**Re: Mary Drake Building, 1216 Forth Street SW, Grading and Drainage Plan  
Engineer's Stamp dated 8-22-04 (K14-D90)**

Re: The Mary Drake Building, 1216 Fourth St SW, Traffic Circulation Layout  
Architect's Stamp dated 9-28-04 (K14-D90)

*Addressed  
10-5-04  
WAG*  
**Re: The Mary Drake Building, 1216 Fourth St SW, Traffic Circulation Layout  
Architect's Stamp dated 9-28-04 (K14-D90)**

**C-1**

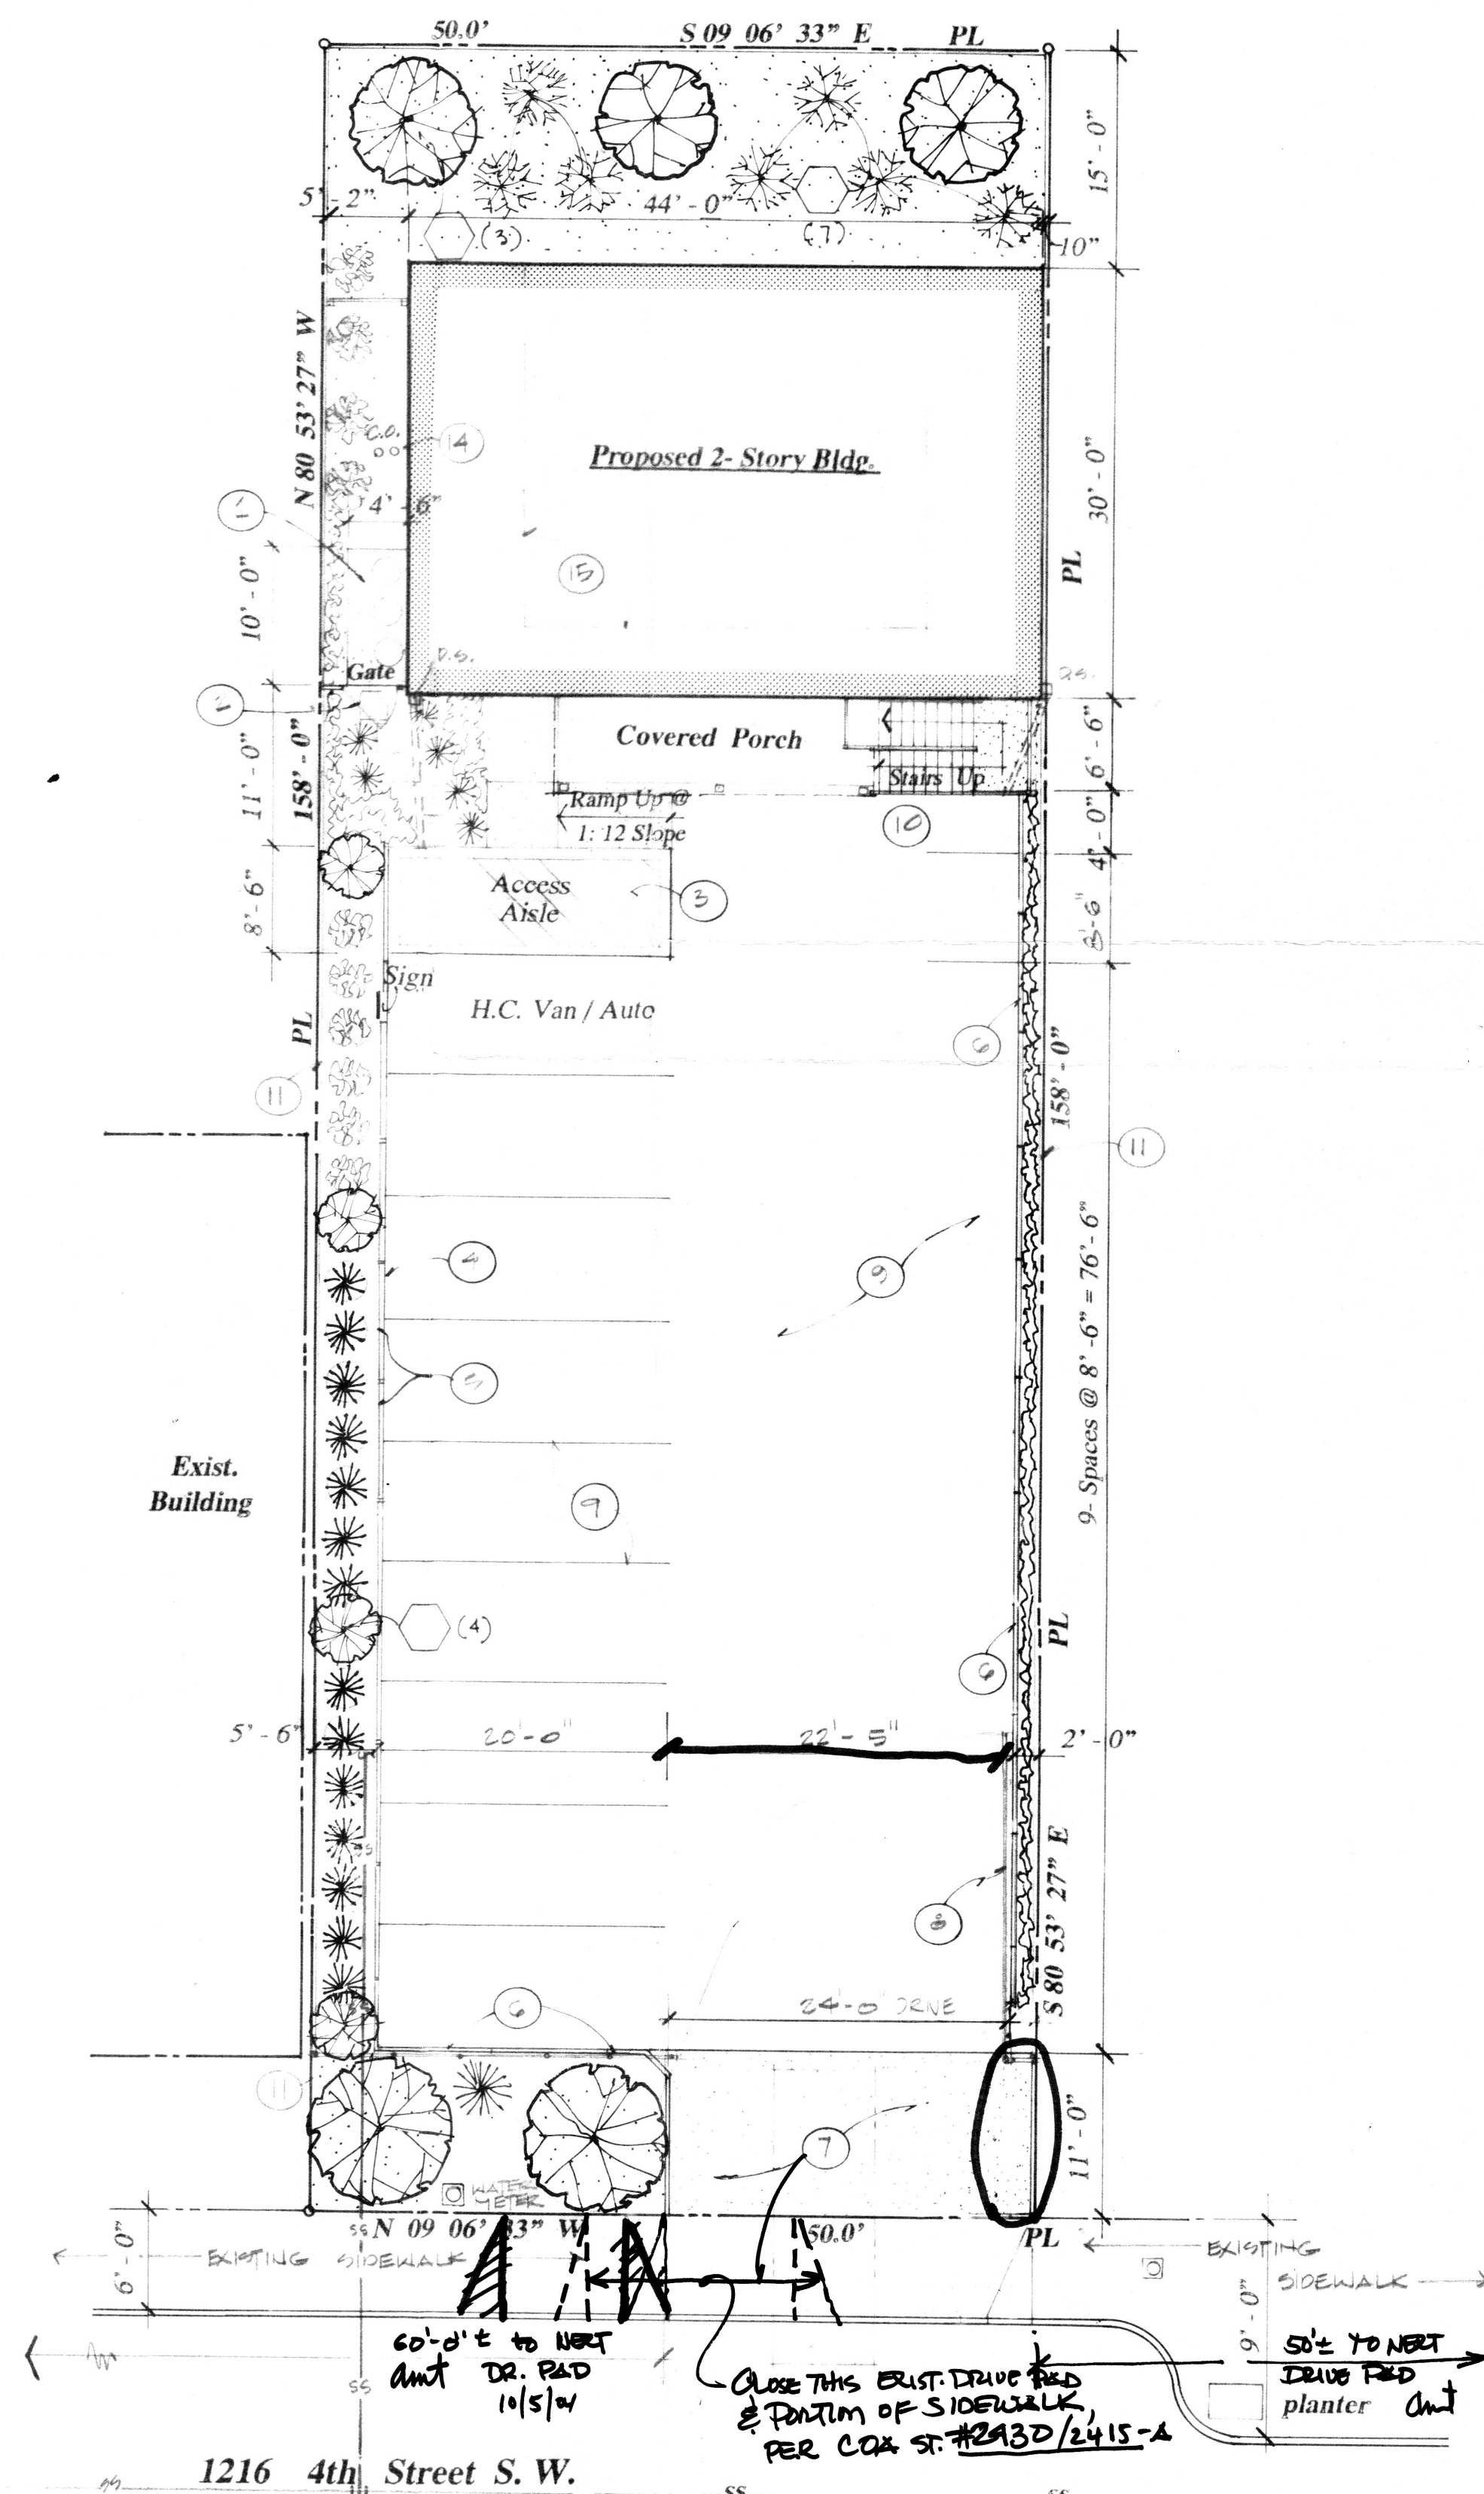
Based upon the information provided in your submittal received 9-29-04, the above referenced plan cannot be approved for Building Permit until the following comments are addressed:

1. Please show the location of the nearest driveway on the adjacent lot.
2. Add a note regarding the closure of the existing driveway and the building of new sidewalk, curb and gutter in this area.
3. The survey data provided indicates the existing drive is shared with lot 27. Please address this.

I am herein responding in writing to your letter in regards to the above captioned project. I have also modified the drawing (C-1) accordingly in reference to certain line items addressed in your letter. I am also submitting 2 copies of the revised C-1 drawing for final approval.

- Item # 1: I am referencing the applicable city standards on the revised drawing.
- Item # 2: Existing Conditions: the lot is vacant, with a layer of thick bark mulch and conc. auto bumpers set up to accommodate the parking of autos., the owner has used it as a rental lot for parking to this point in time.

- Item # 3: I have identified the nearest driveway for the property on the North by a dimension on C-1.
- Item # 4: The owner wishes to close off the property and building after hours by having a wrought iron gate opening to one side so it will not interfere with access to parking spaces. The queuing, as you refer to the inset, is for the purpose of approaching the gate in the mornings when it is locked and being able to go unlock it and swing it in and not be park-in 4th street.

- Item # 5: The existing drivepad is located approx. in the center of the lot's front and does not permit me to plan the parking on the north side as shown so it needs to be located to the south side for proper access to property.

- Item # 6: Attached are two new revised C-1 drawings.
- Item # 7: Street front sidewalk is existing, also see a copy of the original survey.
- Item # 8: Vicinity Map is shown on the revised C-1.

- Item # 9: It is our understanding that conc. bumpers are allowed at the edge of parking areas; although I had shown them in the wrong location, I have relocated them and there is now 20' deep parking spaces.
